**RE: Creekside PRD - Response to Technical Review #2
PA23-005**

Please refer to our responses below which address all review comments received from the City of Marysville dated 8/28 for planning, 9/25 for surface water, and 9/27 for traffic. Located at 7808 40th Street, 7811 & 7715 40th Street NE, APNs 29050200100200, 29050200100300, and 29050200100400. You will find the markup comments listed in the order that they were written followed by our response in *italics*.

HORIZON VIEW HOLDINGS, INC.  
**CREEKSIDE**  
 PRELIMINARY WATER AND SEWER PLAN

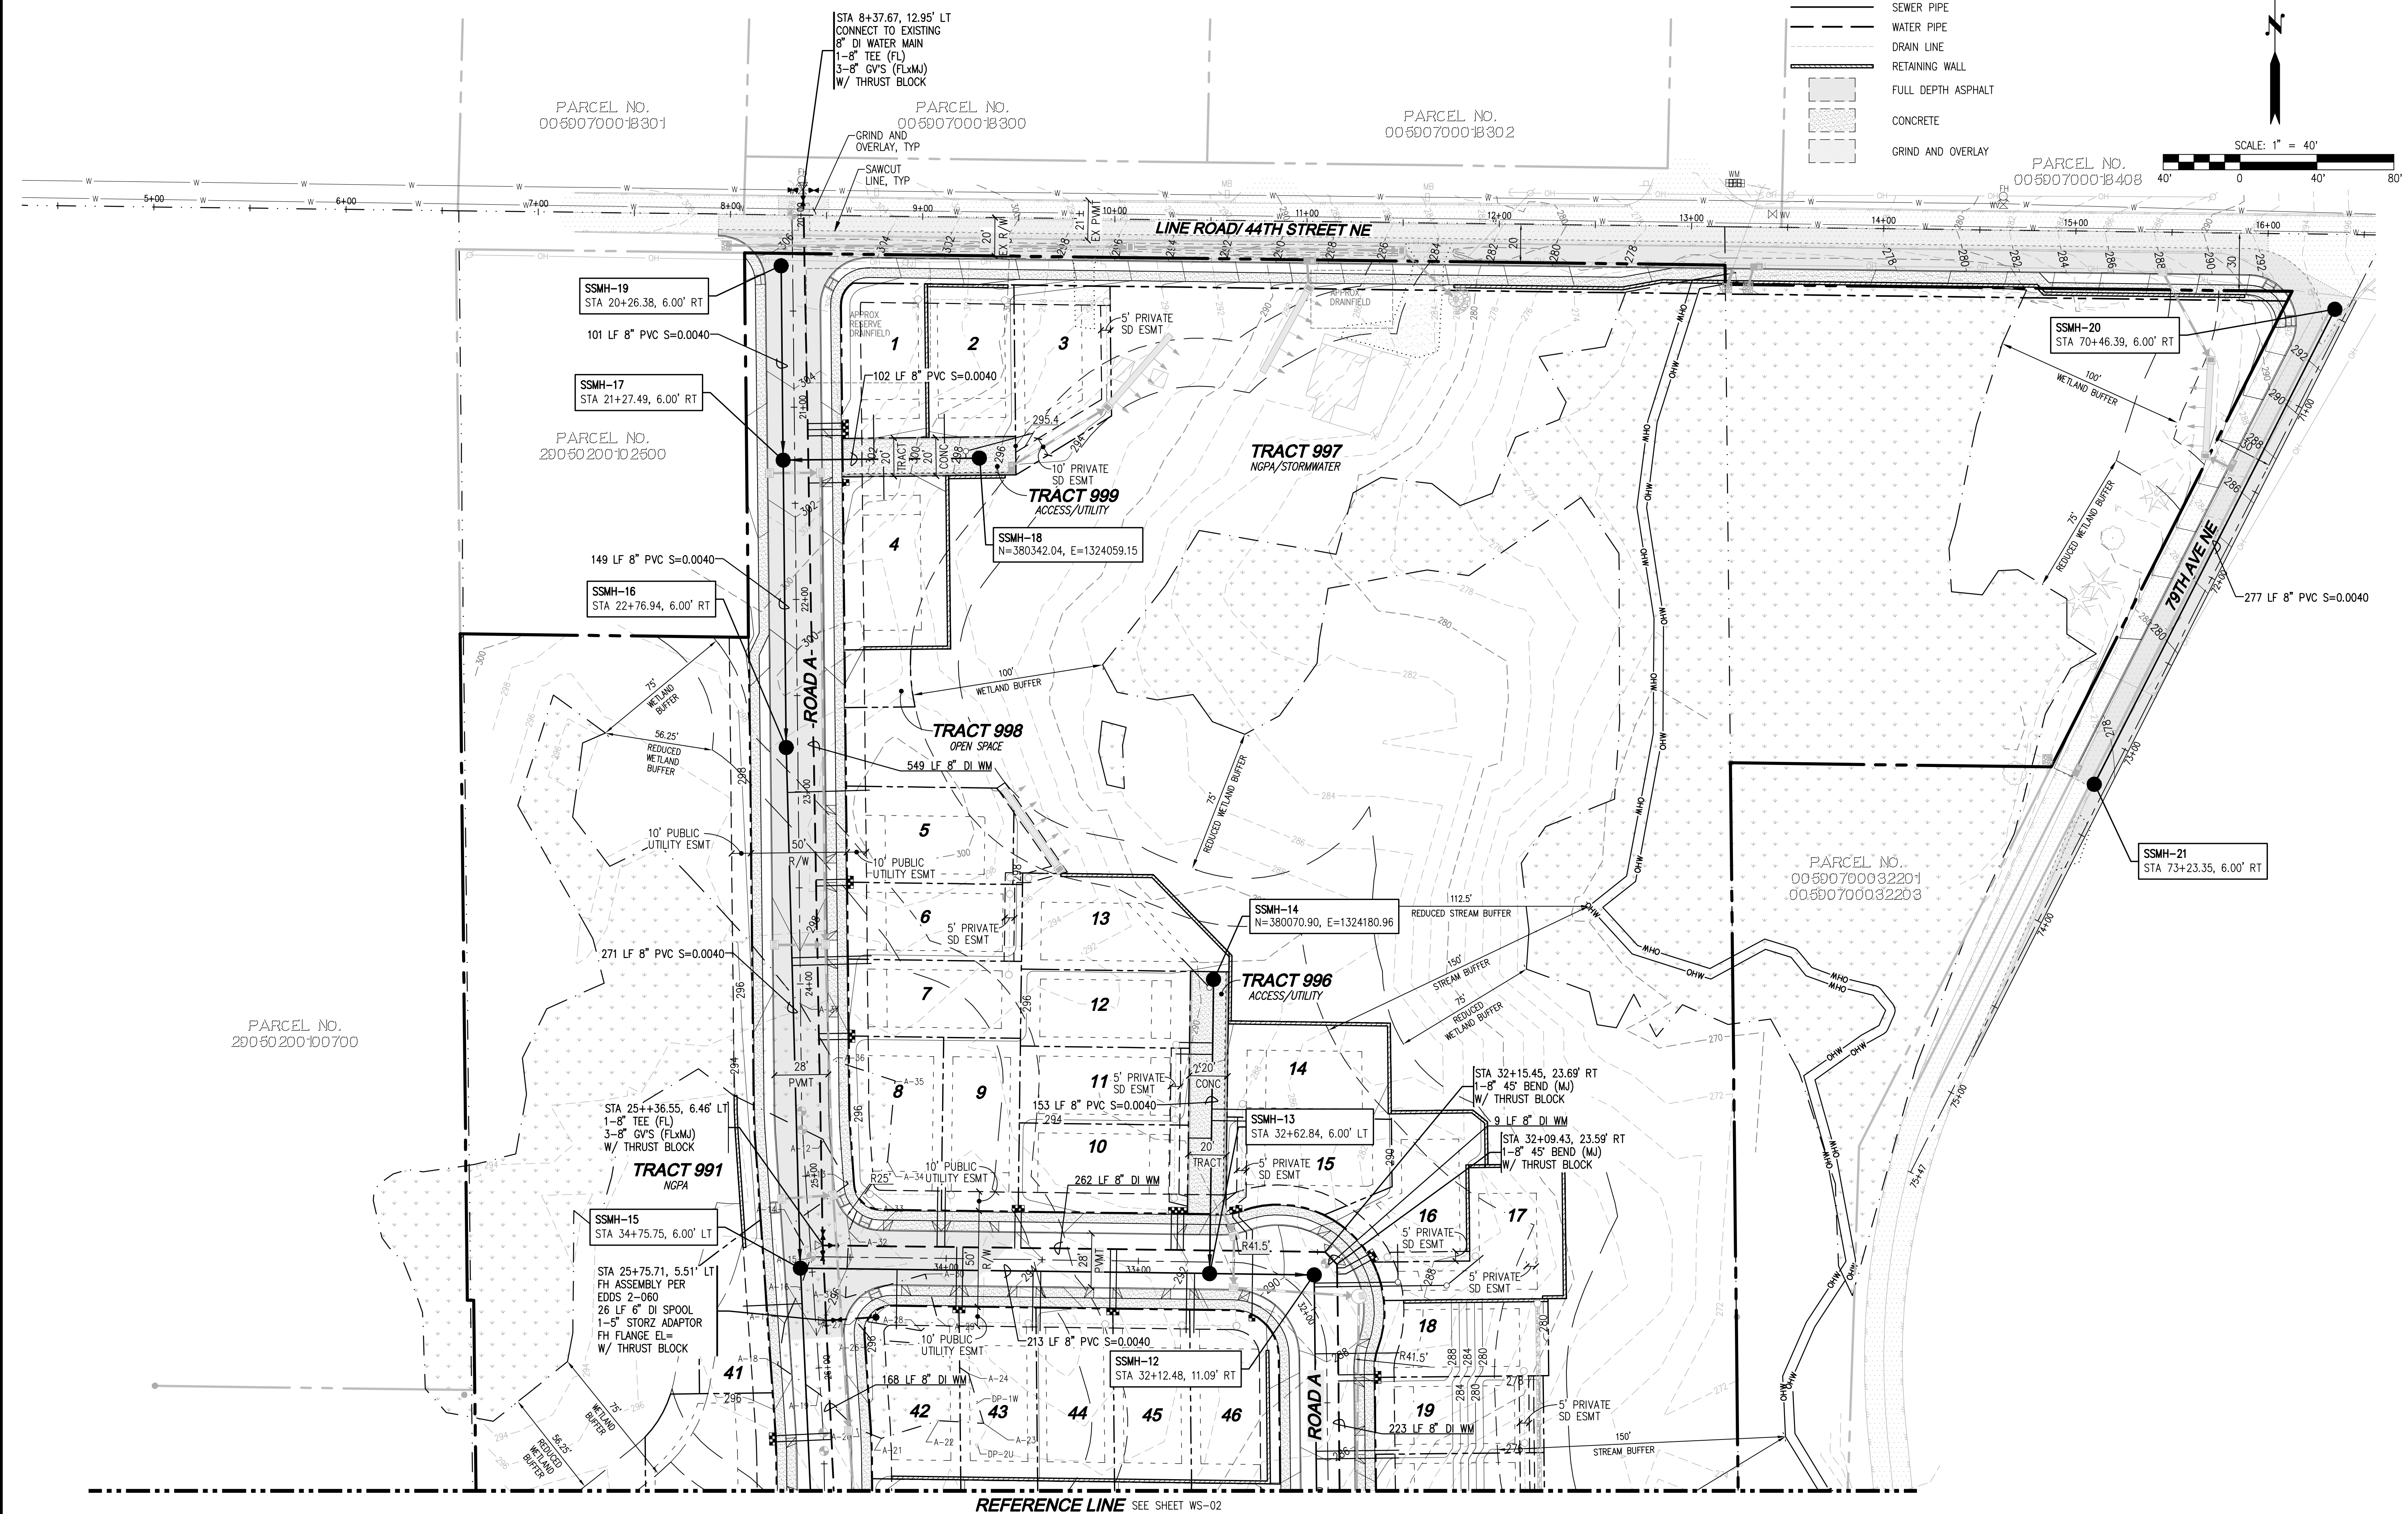
8. Sheet 13 of the civil plans has incorrect lot numbers. Please be sure that all sheets accurately depict the revised layout and lot numbers on future submittals.

Response: Inaccurate lot number labels on sheet WS-01 have been corrected.
